84 Annandale Avenue
Bognor Regis
West Sussex
PO212EX
10th April 2018

86 Annandale Avenue planning proposal – BR/42/18/PL

DRAWING
PROPOSED PLANS
DRAWING No
247/04
SCALE 1:100
DATE PER 2019
REVISION
DRAWN
CHECKED
LA

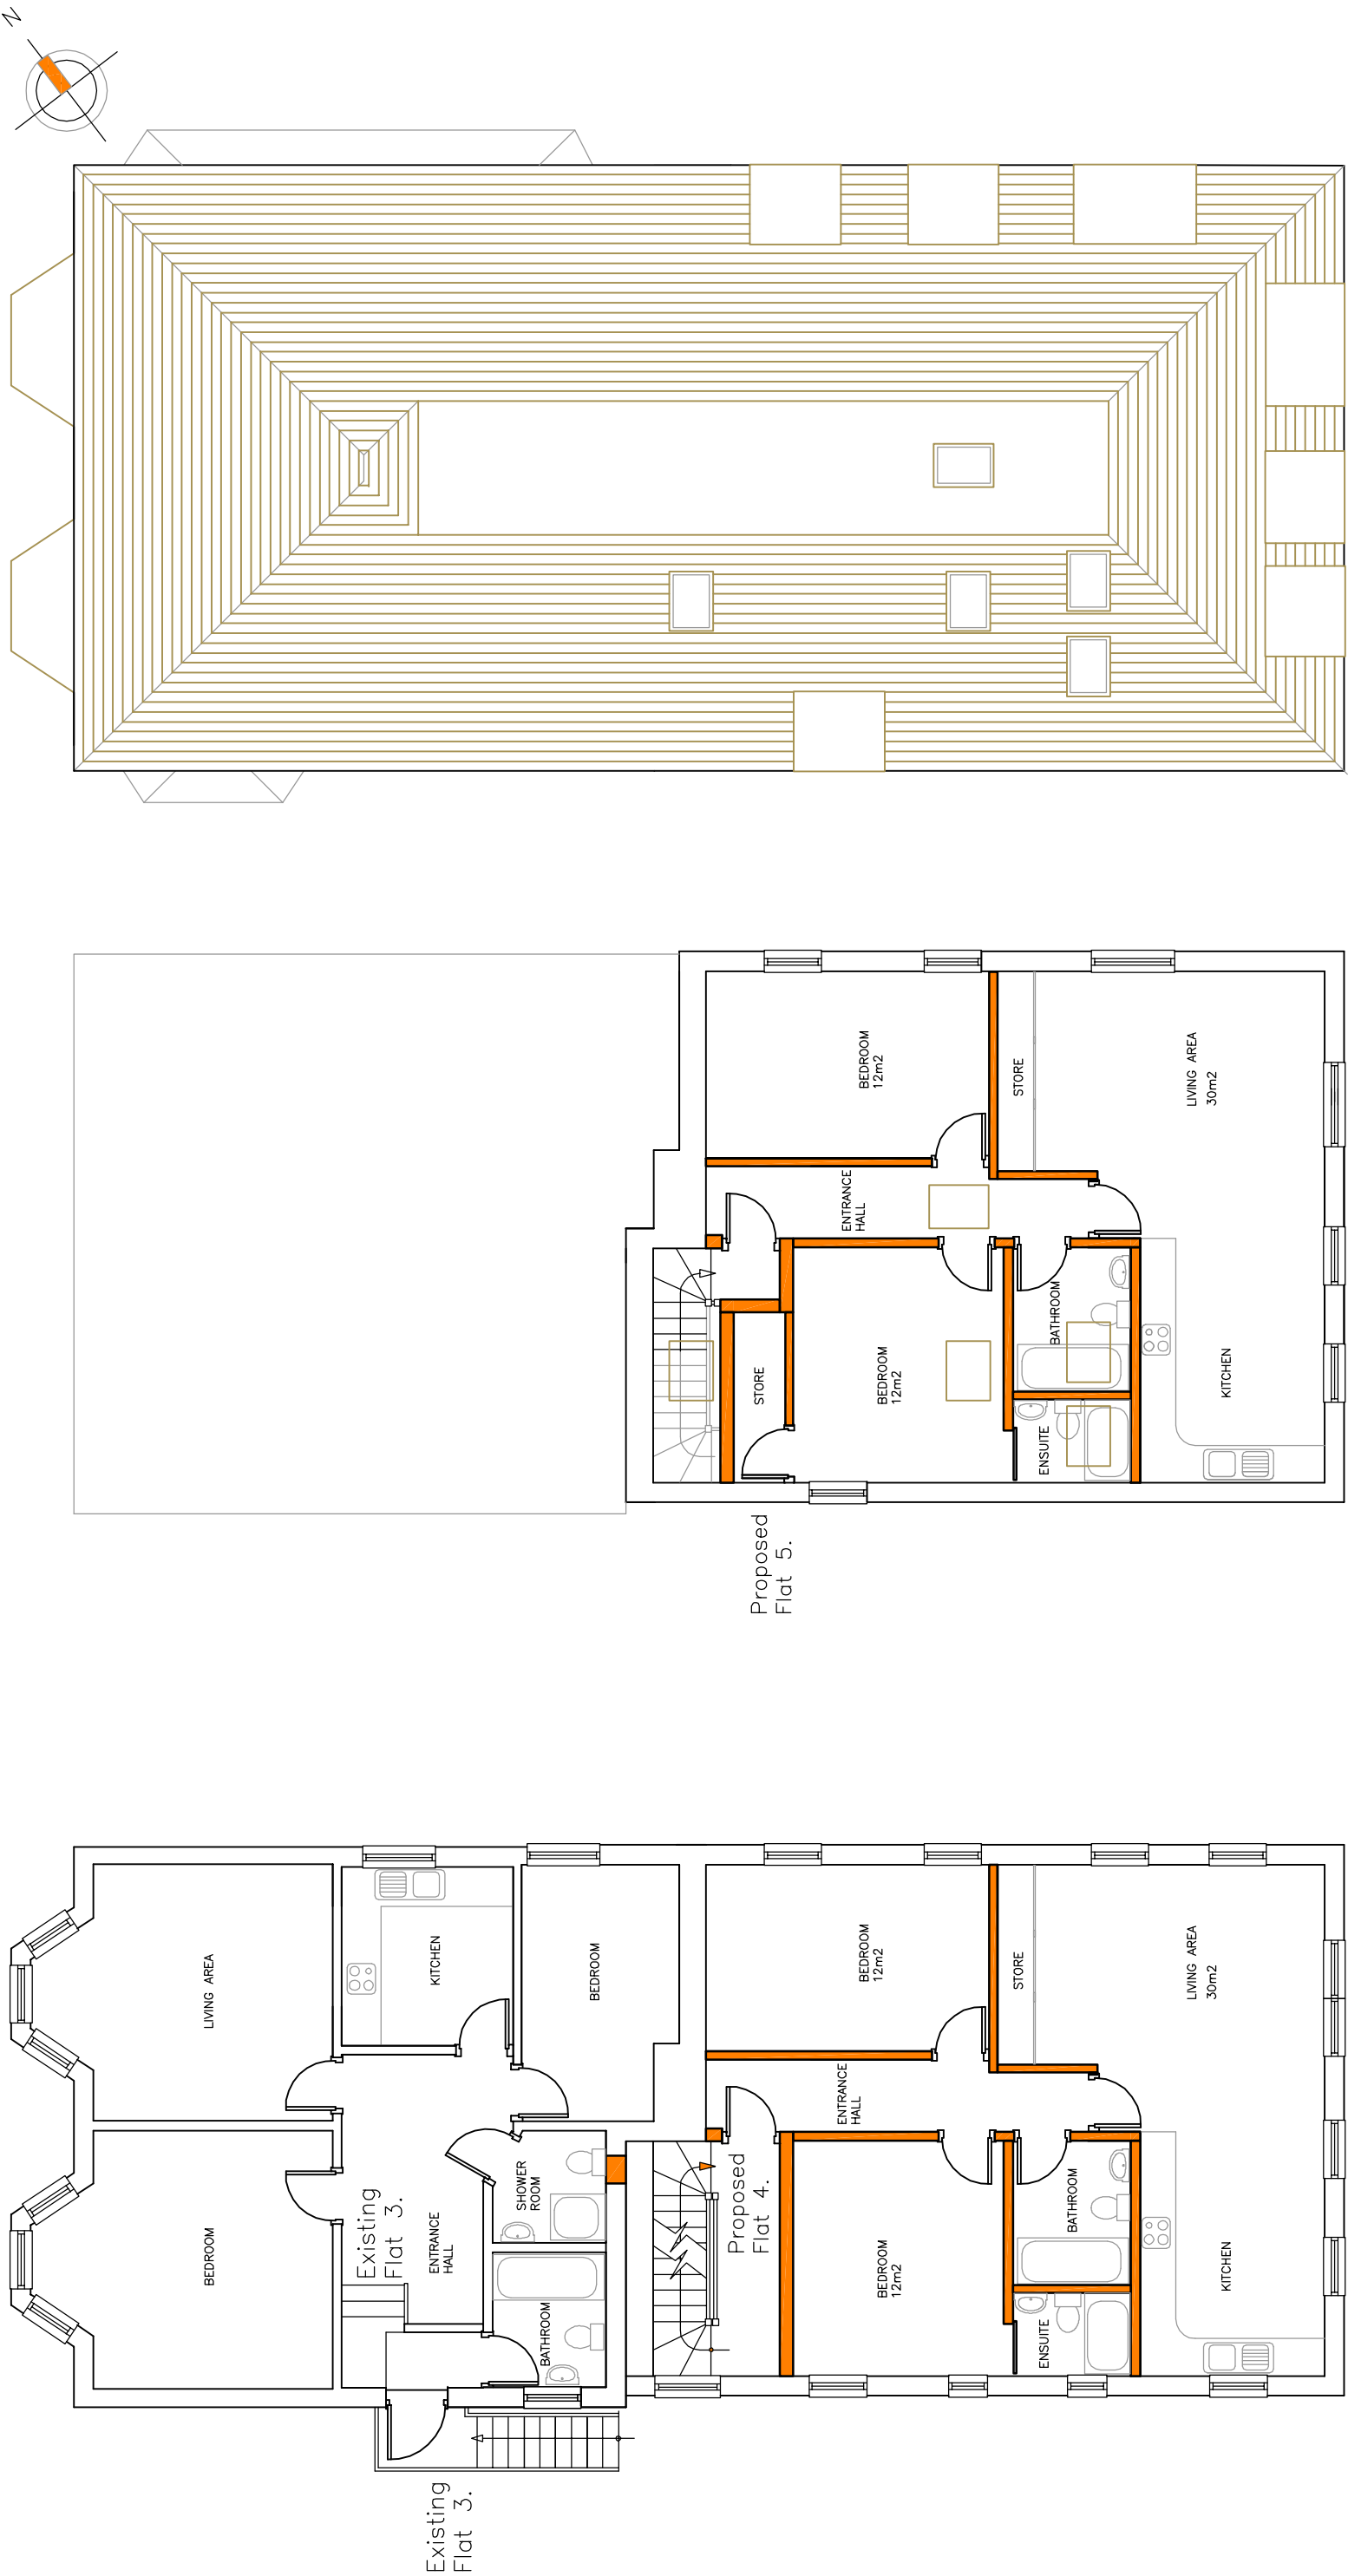
I am one of two elderly ladies who moved to 84 Annandale 15 years ago to enjoy a peaceful retirement in our lovely house with its delightful private garden where we can feed and watch the wildlife. When 86 was a playschool, it was nice to hear the children laughing and playing. We were not aware that there had been yet a further request to extend the single story extension at the rear of 86 Annandale Avenue until a neighbour showed us a photograph of the planning notice and copies of the plans showing the proposed extra two floors to be added to the existing single story extension at the rear of 86 Annandale Avenue.

Our hearts sank as we realised the full extent of the total loss of privacy we would suffer should this, inconsiderate planning request be approved. Our light and airy kitchen will be turned into a dark dismal room as the proposed building would block out all natural sunlight. We love sitting in the privacy of our garden during the summer months, entertaining friends and looking after the flower beds, without prying eyes watching over us. This proposal will leave our garden overlooked by ten or more windows, with a total loss of privacy in our rear facing rooms.
